Statement of Common Ground with Beverley and North Holderness Internal Drainage Board ~~(draft)~~

Revision 34 (tracked and unsigned)

~~October~~December 2025

Figure 1.2: Land Areas and Cable Routes Plan with Field Numbering System

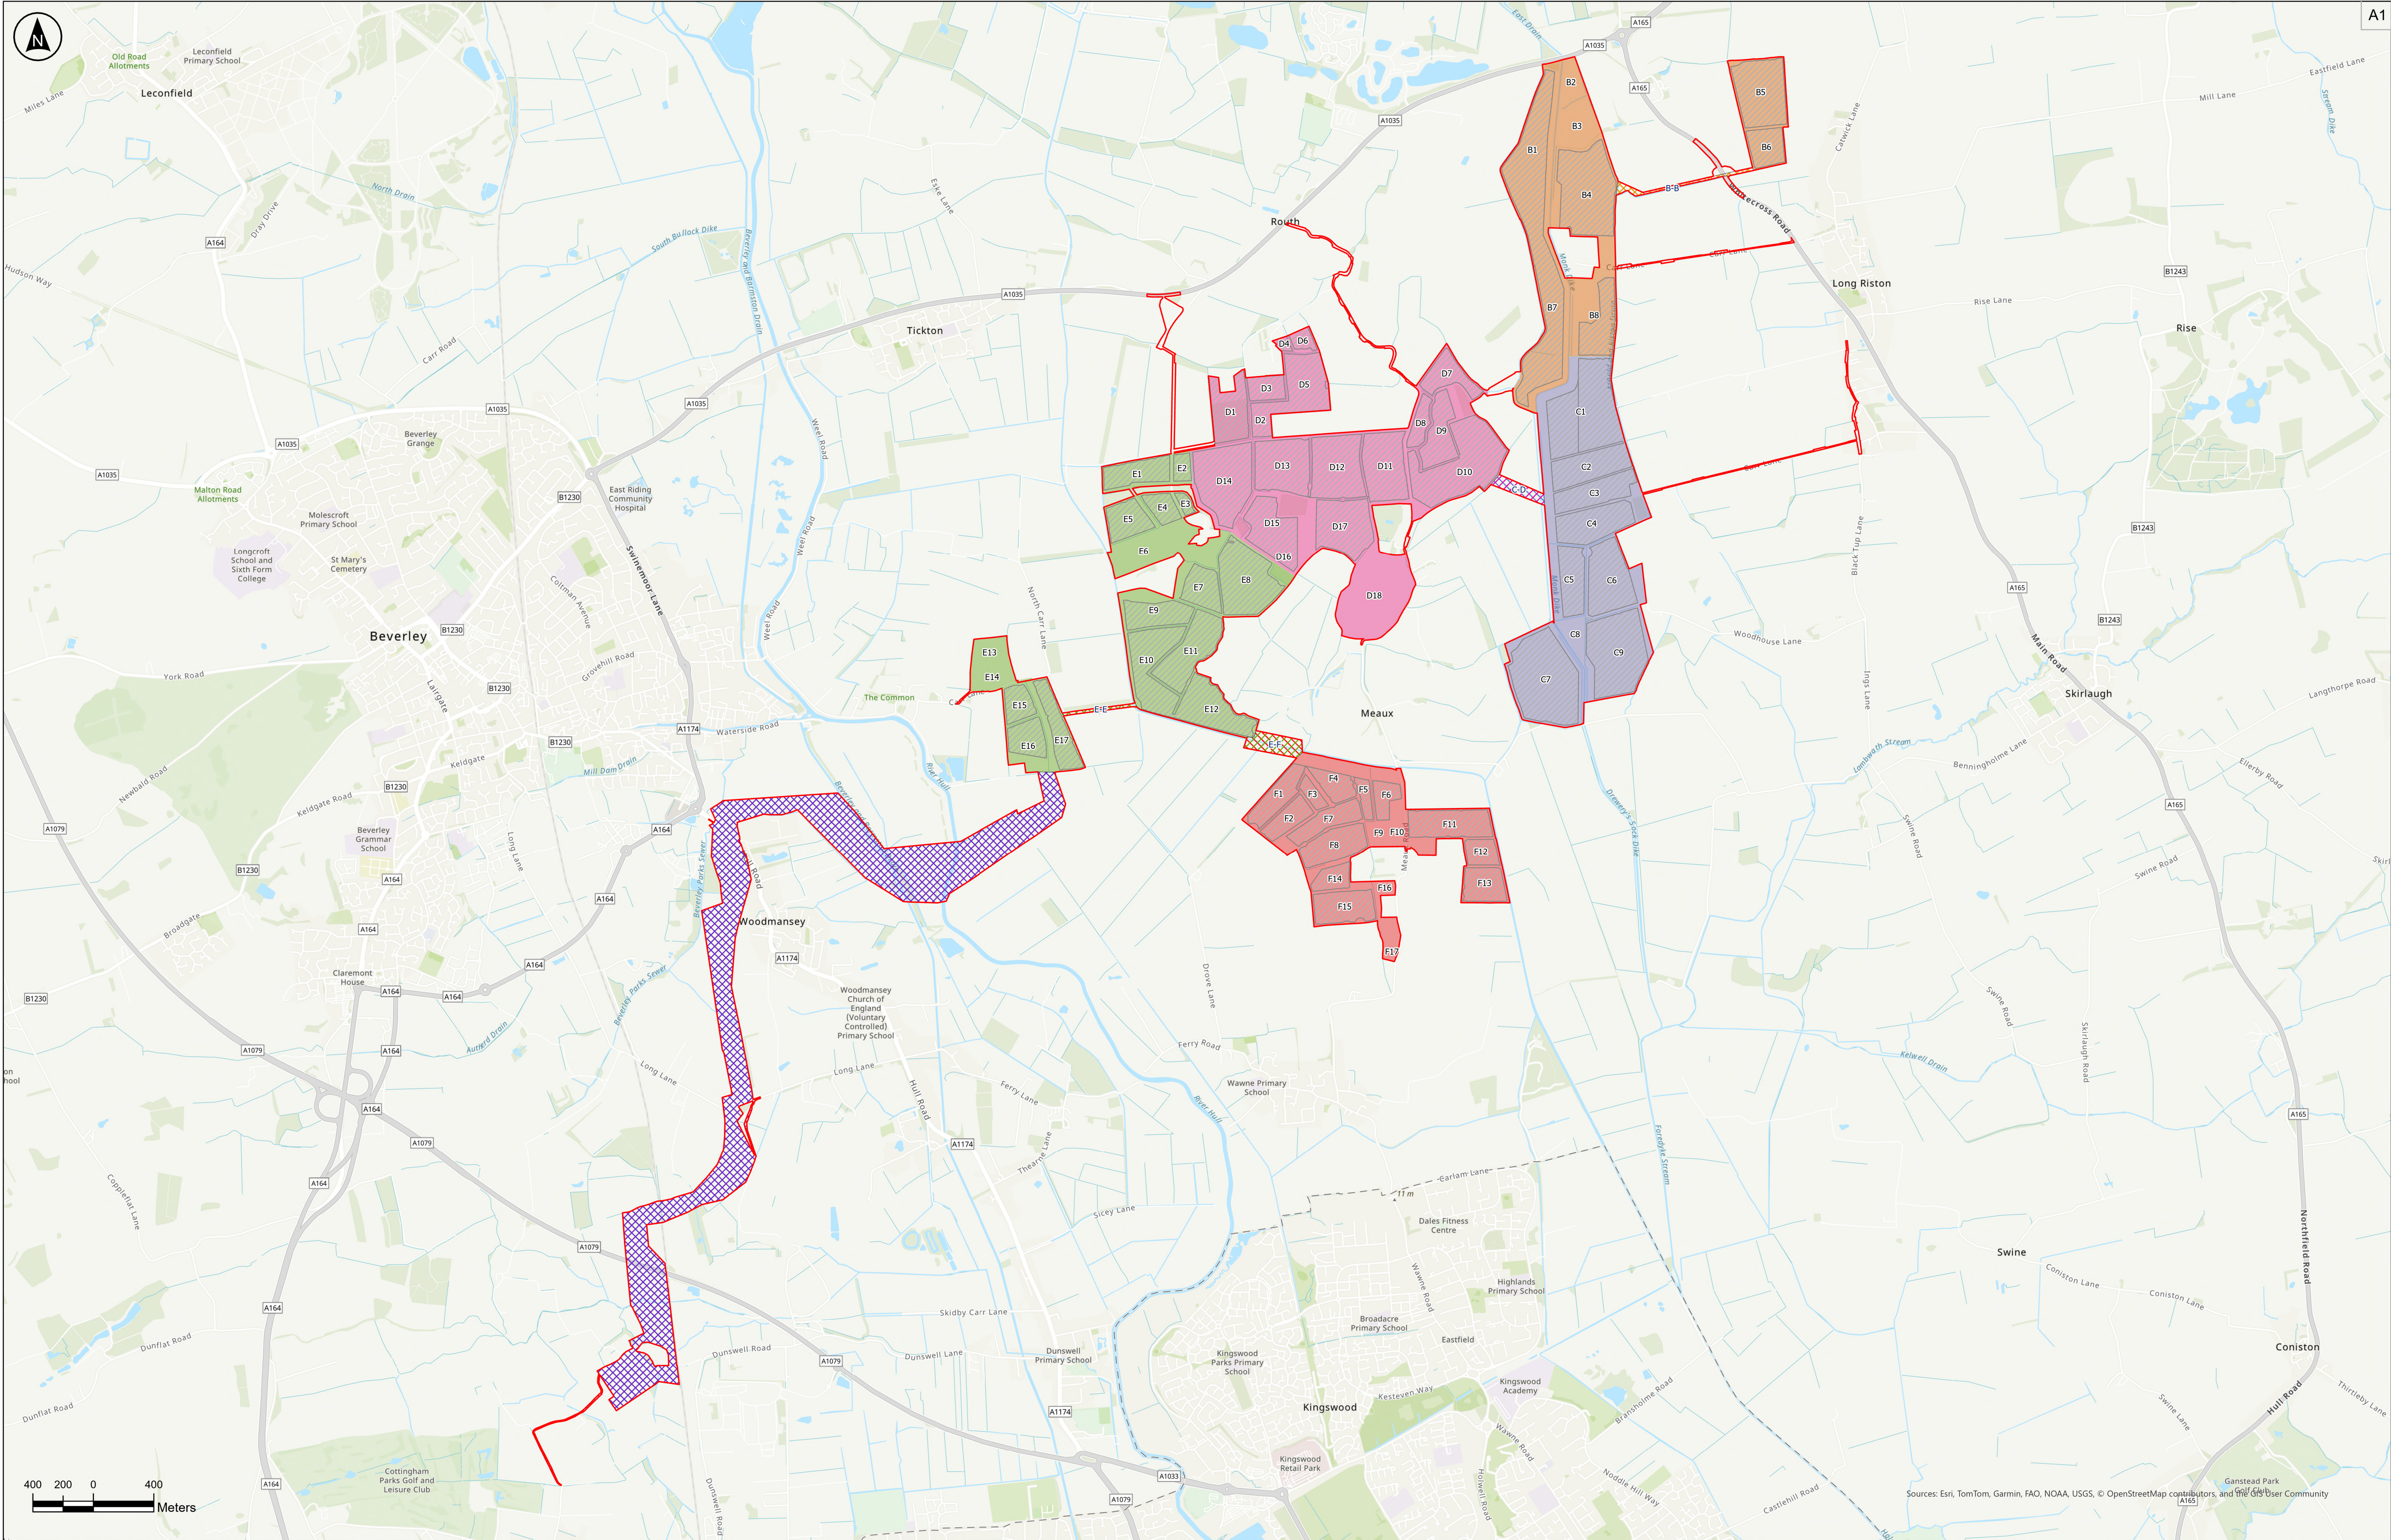
Ref	Topic	Beverley and North Holderness Internal Drainage Board Position	Applicant's Position	Status
	strategy – solar panels <i>Hydrology and Flood Risk</i>	Holderness Internal Drainage Board confirms it will not request a drainage strategy for the solar panels themselves on the basis that there must be a greenfield buffer area of 9m from the bank top of a Board-maintained watercourse and to an ordinary (non-Board maintained) watercourse, and that the area underneath the solar panels must have continuous grass/vegetation all year round.	Management Plan [EN010157/APP/7.5 Revision 3] , the design of the Proposed Development includes a minimum 10m offset from all watercourses (other than locations where span bridges are required to be installed or where existing crossing points or culverts require upgrading) and the solar PV modules would have grass beneath them year-round.	
IDB07	Surface water drainage strategy – inverters, substations, compounds <i>Hydrology and Flood Risk</i>	It was originally agreed with East Riding of Yorkshire Council (Local Lead Flood Authority) and the Beverley and North Holderness Internal Drainage Board in an online meeting on 6 June 2024 that there would be no positive drainage. Instead, rainwater would be directed to ground as per the existing Site response to rainfall. However, in an email dated 26 June 2025 and in its relevant representation [RR-004] , Beverley	<u>The Applicant welcomes this response.</u> The concept drainage strategy <u>is presented</u> within ES Volume 4, Appendix 5.6: Flood Risk Assessment [EN010157/APP/6.4 Revision 35REP5-030 to REP5-046] . <u>This has been updated to</u> includes a formal drainage strategy (with positive drainage) for the substation hardstanding areas. The Applicant proposes to drain the proposed hybrid pack areas to ground, mimicking the existing Site response to rainfall. <u>The exception is where there are more than two hybrid packs in a field (field as defined by 'Field Reference' in ES Volume 3, Figure 3.1: Indicative</u>	<u>Under discussion</u> <u>Agreed</u>
